Town & Country Planning Act 1990 (as amended)
Town and Country Planning (Development Management Procedure) (England) Order 2015
Approval of details reserved by condition imposed under AL/139/16/HH relating to condition 3-
surface water drainage & 4-schedule & samples of materials & finishes.
The Coach House Norton Lane, Norton, Aldingbourne

Arun District Council have decided to **REFUSE details reserved by condition for the following reasons:**

<table><tr><td>Drawn By IC</td><td>Scale 1:50</td></tr><tr><td colspan="2">Drawing No. 20037 - BR - 110</td></tr></table>

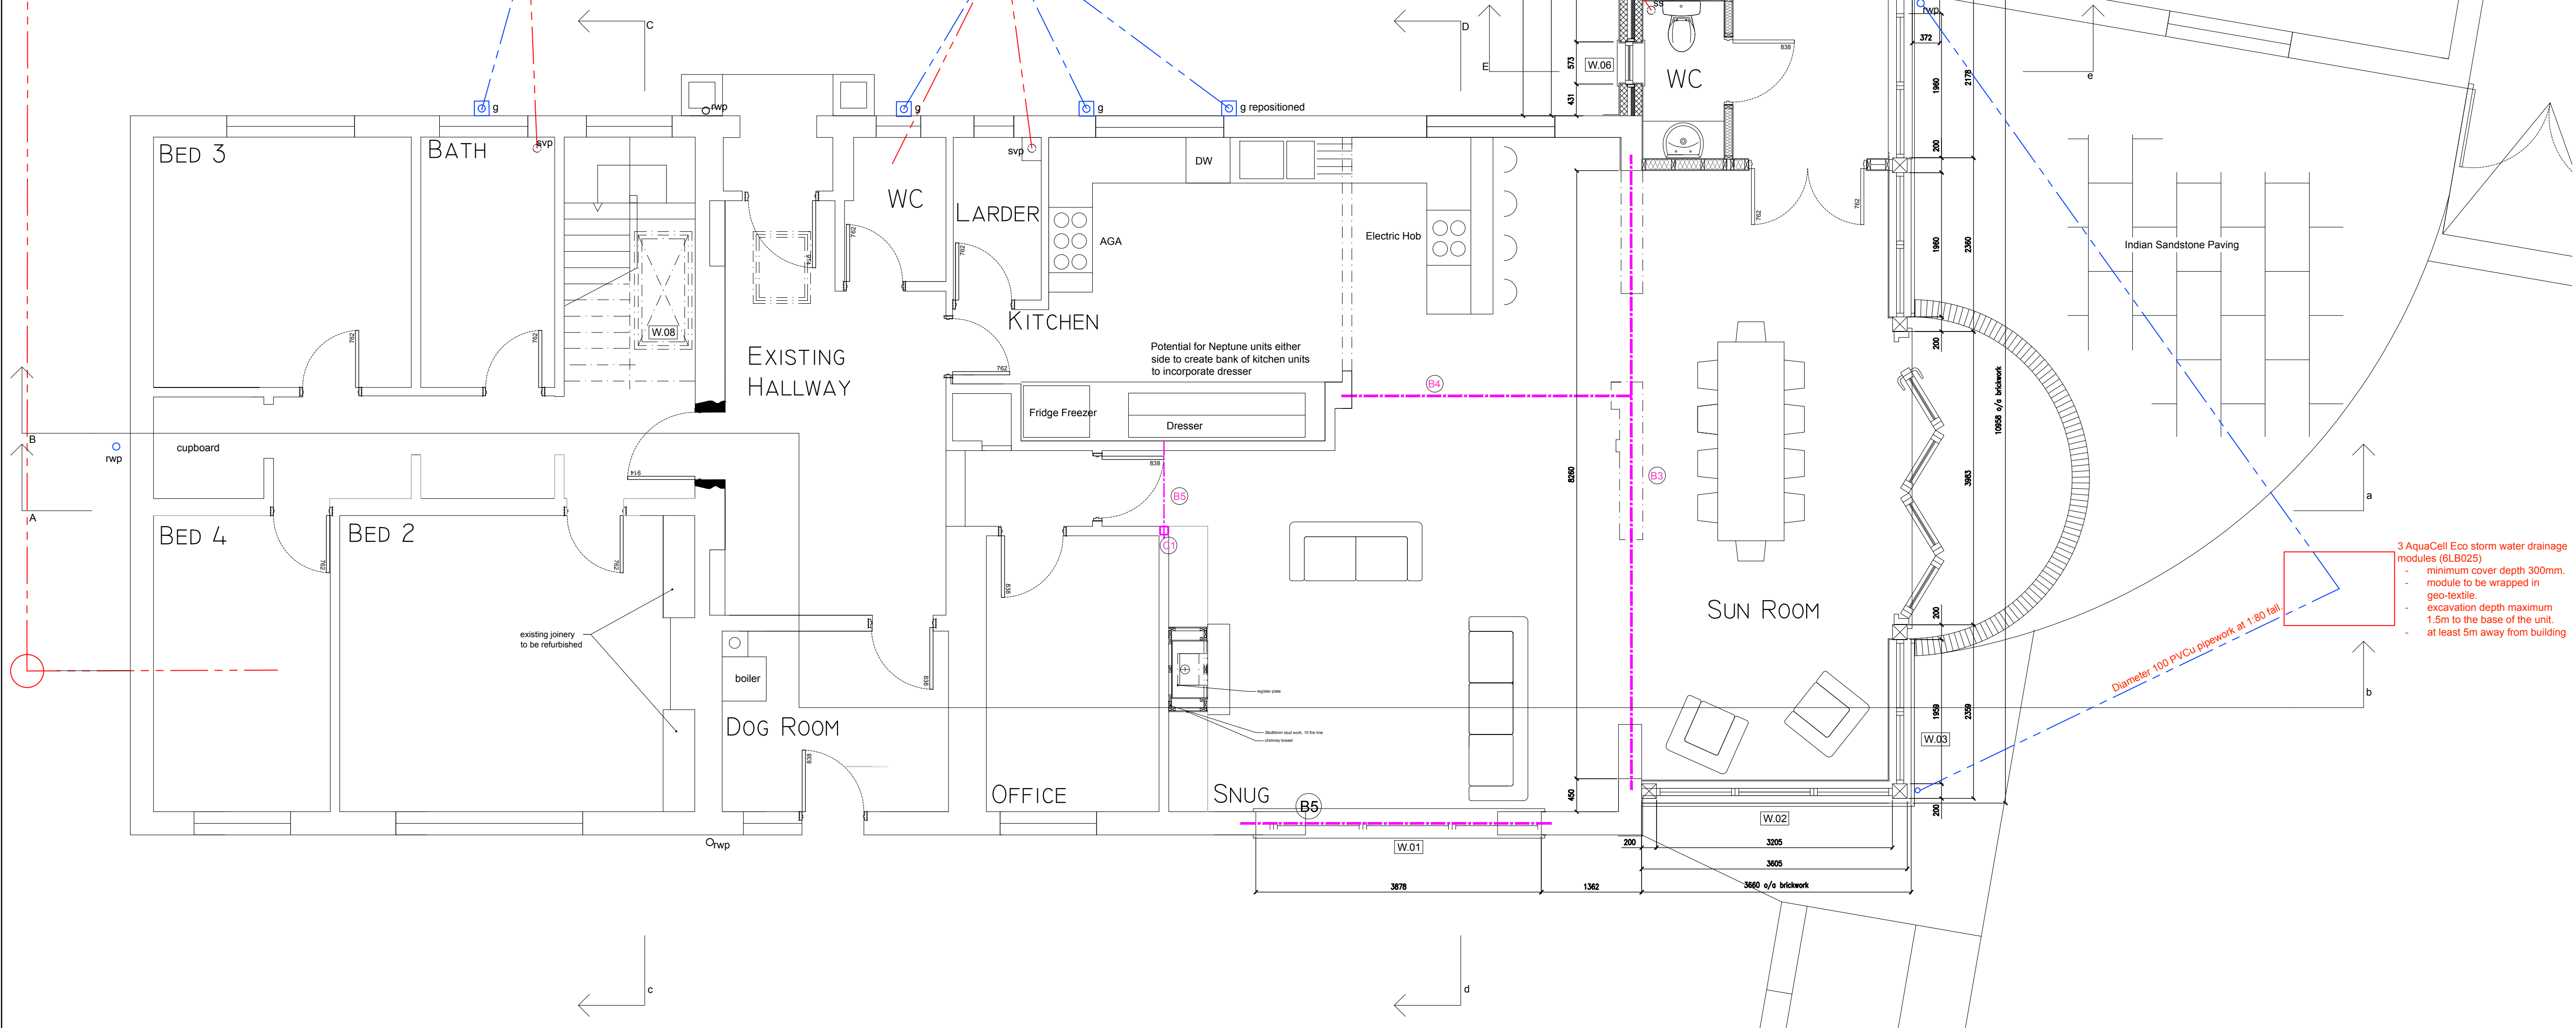
Council Drainage Engineers have objected to the discharge of this condition on the grounds that insufficient details have been provided in respect of the surface water drainage scheme. The required details are as follows:

1. Winter groundwater monitoring;
 2. Winter percolation testing to BRE365 at an agreed depth;
- docdeci

3. Drainage layout including pipe invert levels/soakaway base level, etc;
4. Full construction details of the soakaway;
5. Rainwater pipes to discharge to a catchpit prior to discharge to the soakaway in order to capture silt; and
6. Provide construction detail for the catchpit.
